# V1\_Grading & Erosion Control (GEC) Plan\_COMMENTS.pdf Markup Summary

## EPC Stormwater- Zachary (13)

PCD File PPR2610

GESC COVER SHEET

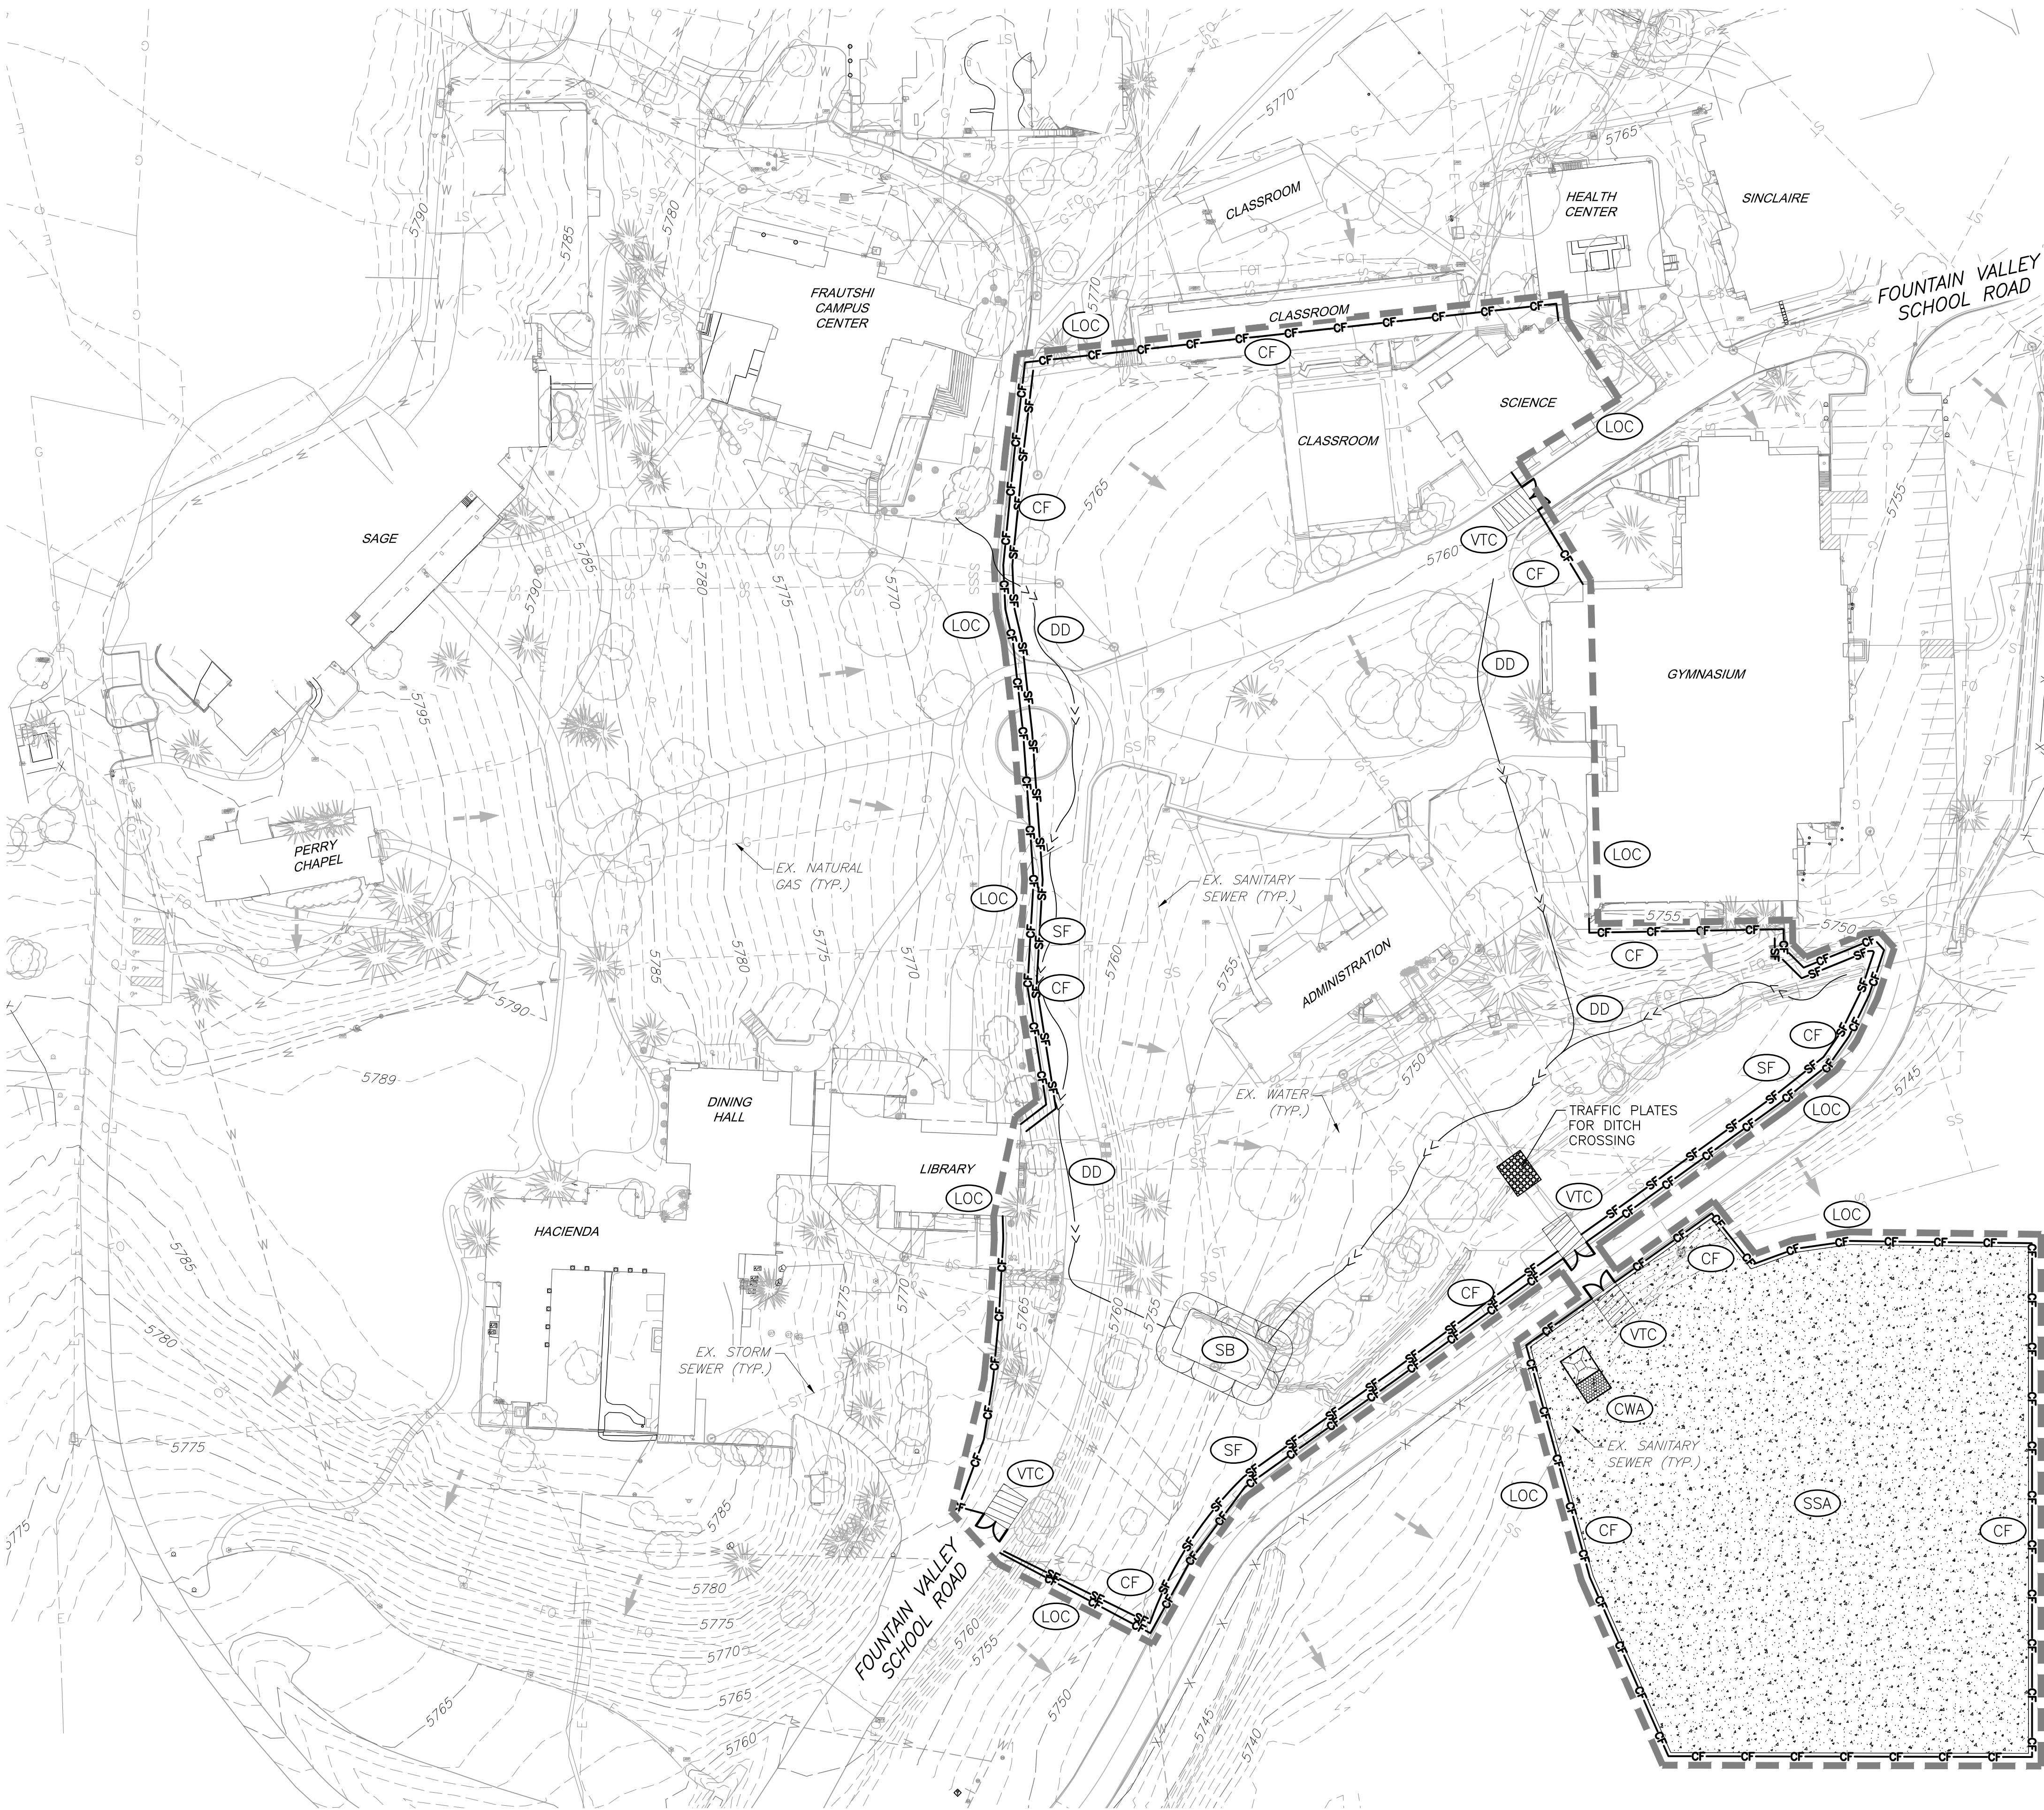
Use signature blocks for stand-alone GEC plan (no CDs)

Stamp and sign Engineer stamp all pages

Sediment Basin (SB)

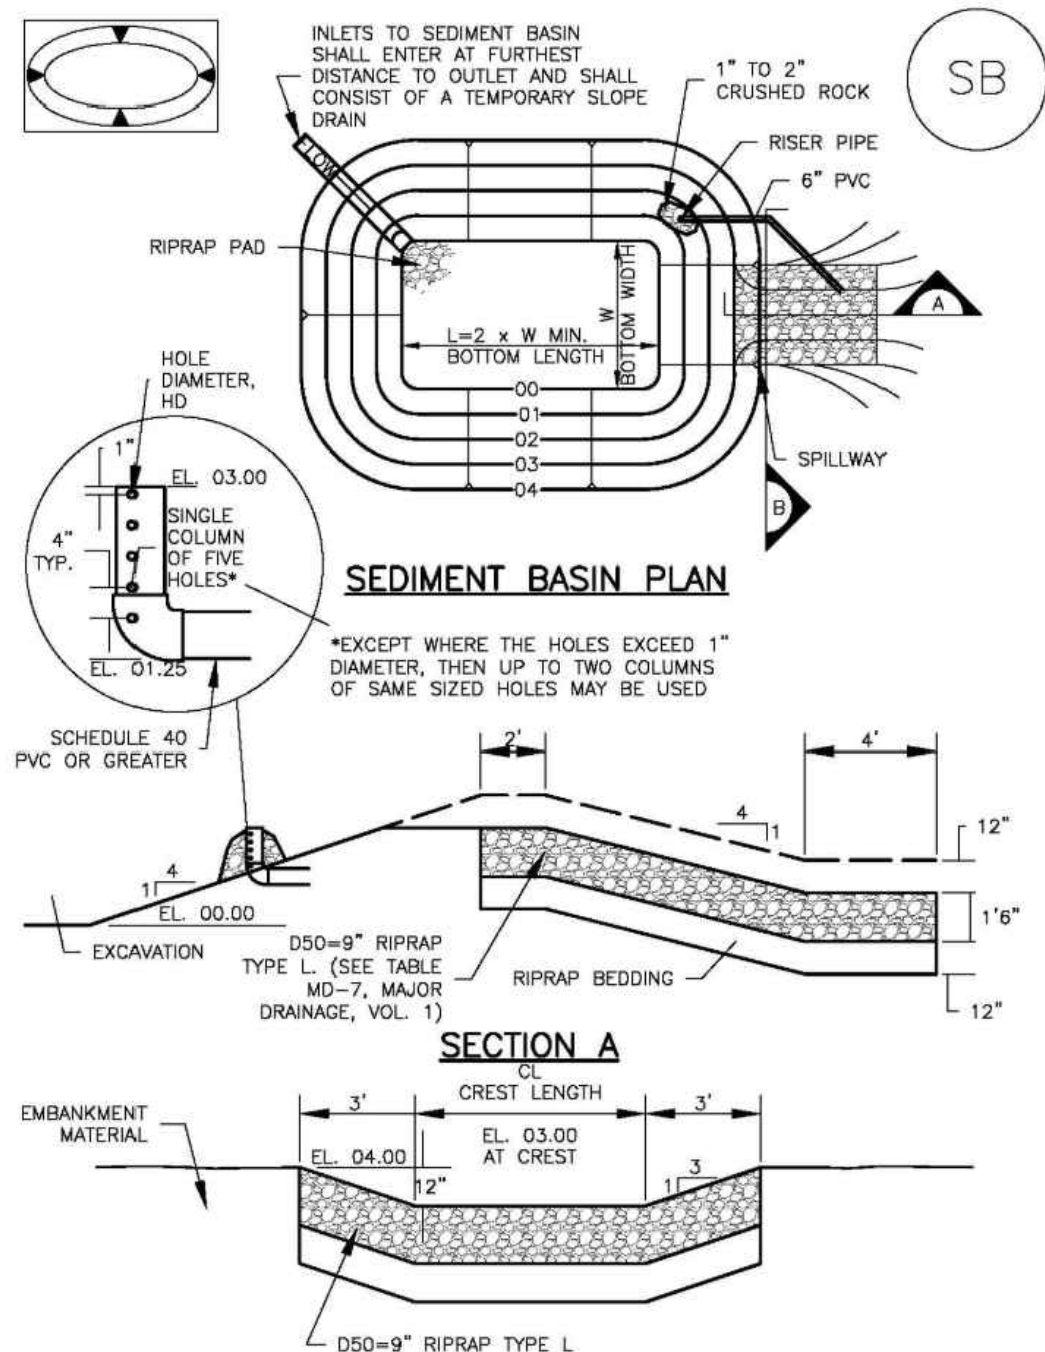
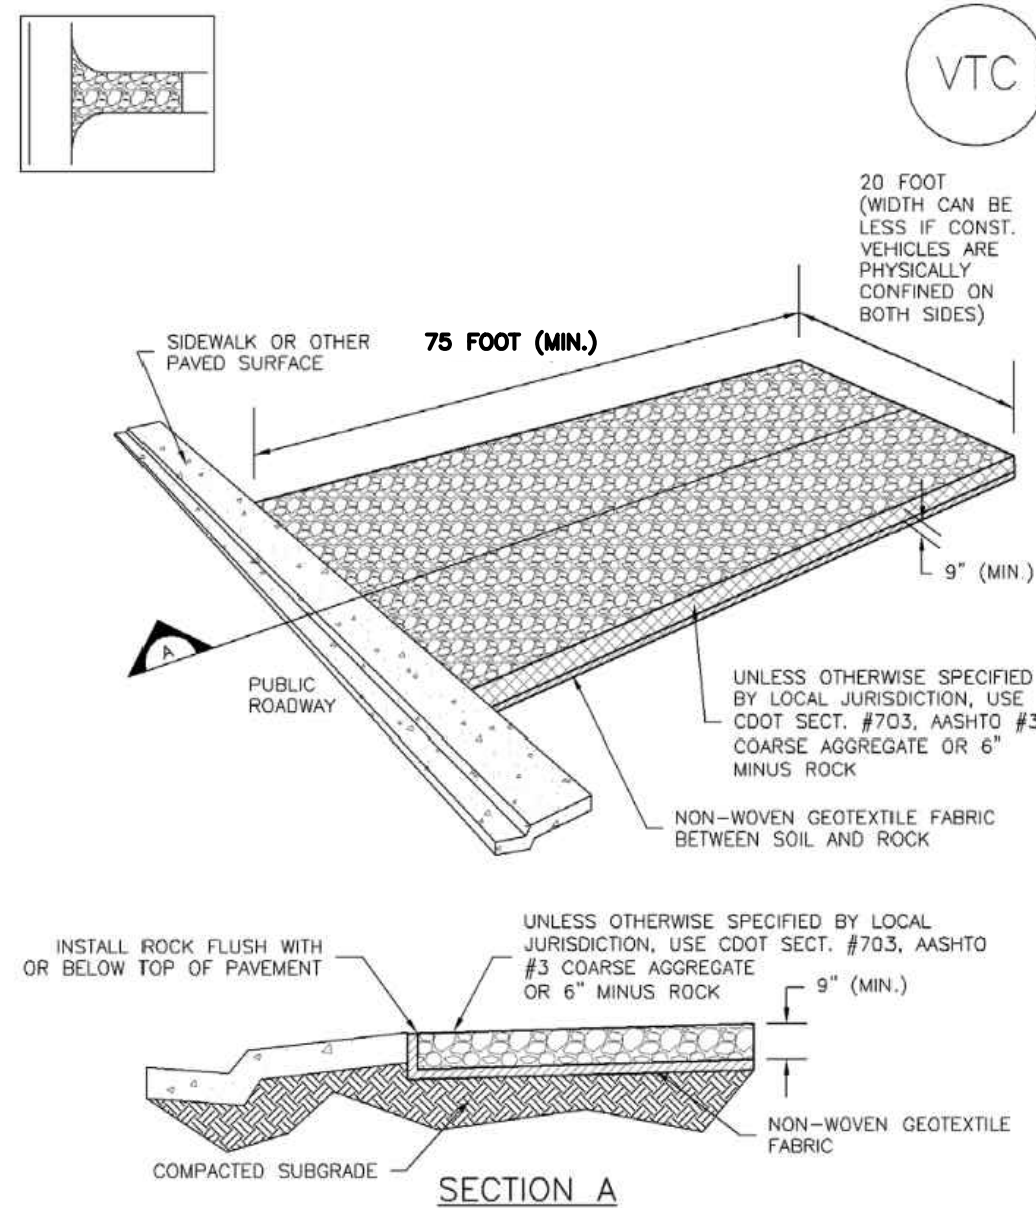
Please notate which line on the table below should be used for the sediment basin, or provide other sizing details specific to the TSB for this site

VTC-2. AGGREGATE VEHICLE TRACKING CONTROL WITH WASH RACK

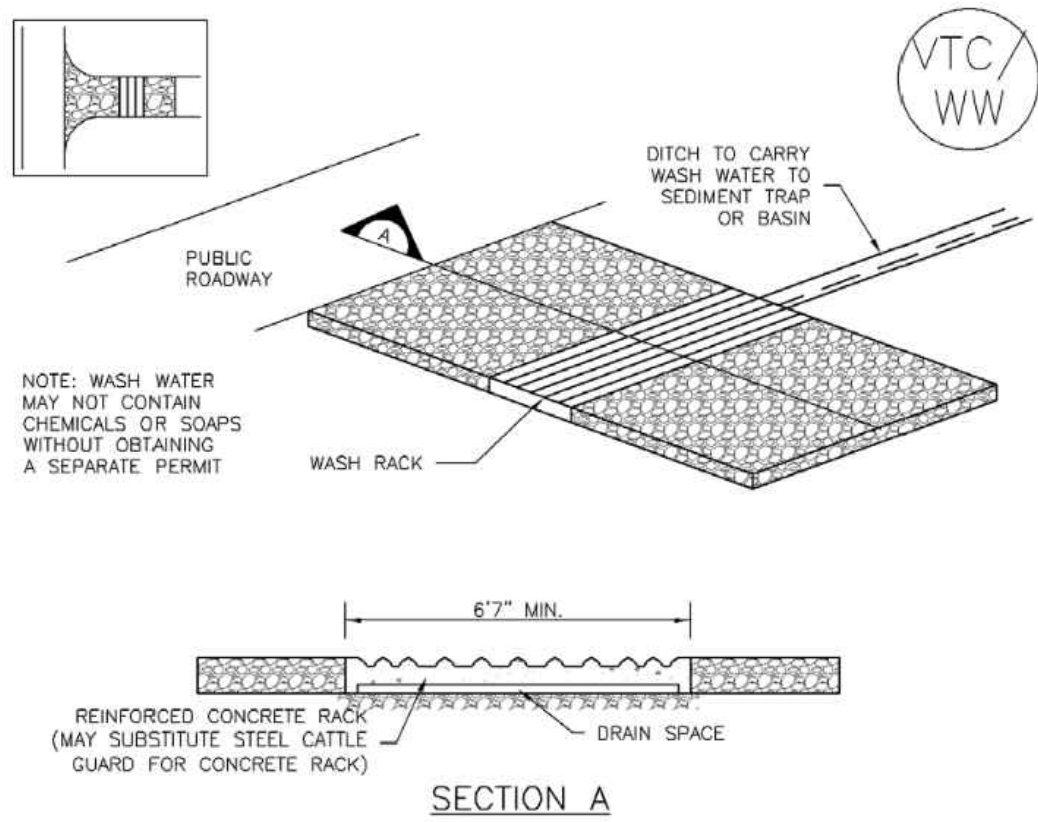
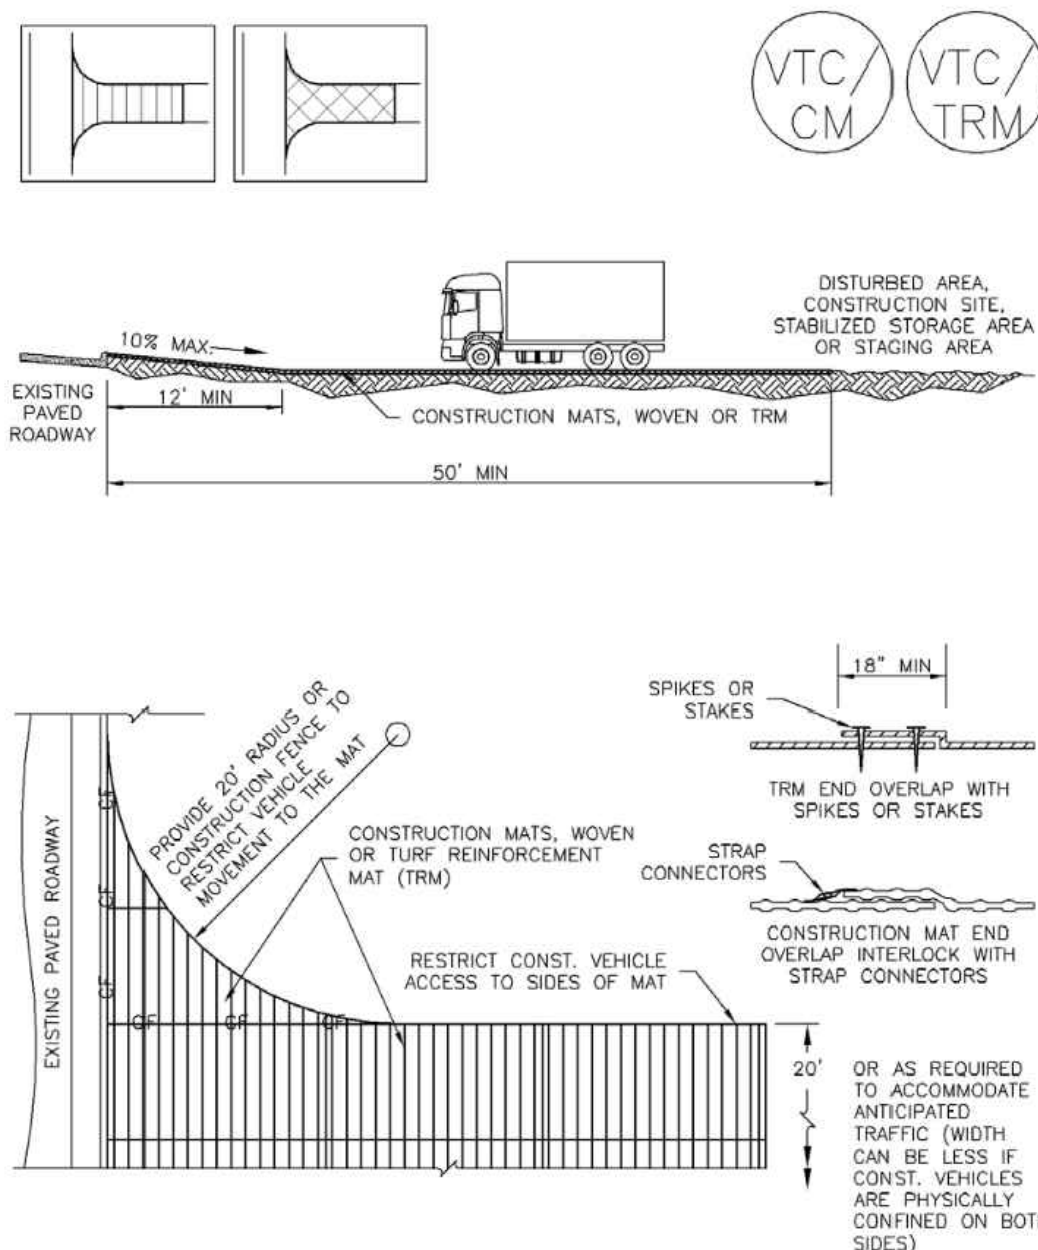
Replace with EPC approved VTC detail (VT-1 and VT-2 in DCMv2, Chap 3.3) or revise to be 75ft min length.
